08 February 2021

Our Ref: L/edp3487/VF/cl

Project Reference: 2019/1244
Site: Darton Lane, Darton

I write to inform you of our response to two sets of comments received from Wildscapes for the above application, received on 23.11.20 and 25.02.21. For ease, I have copied each comment and inserted our response to it below with reference to the appropriate section in the relevant updated document.

INDICATIVE SITE LAYOUT

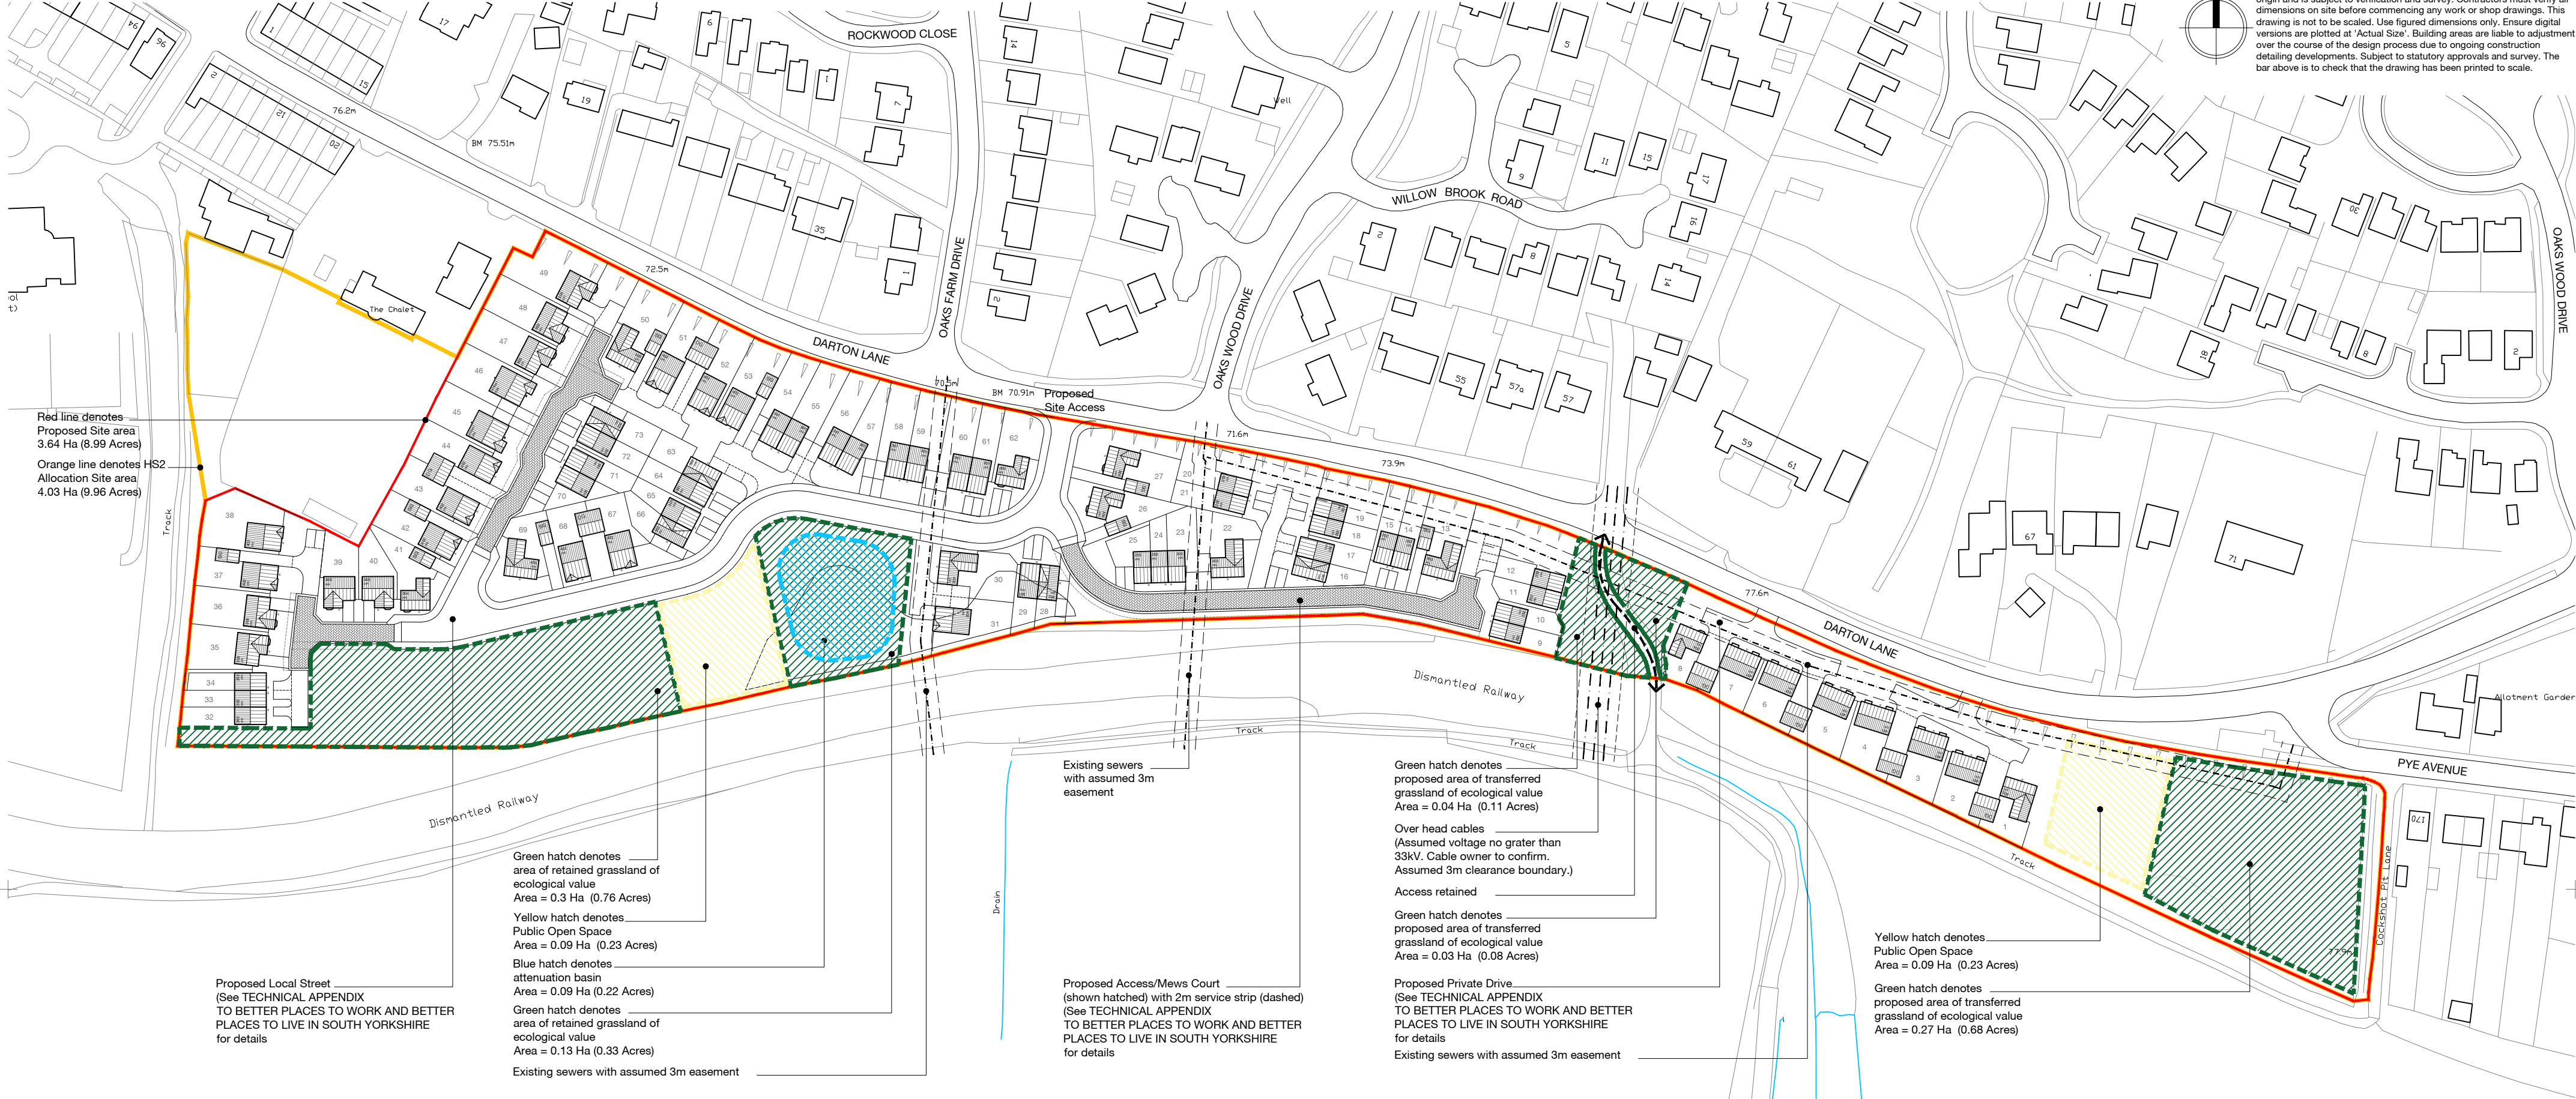
The Design and Access Statement (August 2019) references expectations written into the site allocation of Site HS2, including the retention of species-rich meadows to the west of the site, and retention of a buffer strip of vegetation adjacent to the disused railway line to the south. However the Indicative Site Layout map (Appendix EDP1) shows only partial retention of the meadows to the west, and there does not appear to be a buffer strip of vegetation running along the disused railway line. The proposed attenuation basin would provide a partial buffer.

The parameter plan has been updated to show an ecological buffer (Edward Architecture 0708 EA-A S20201130D). It does not form part of the ecology documents.
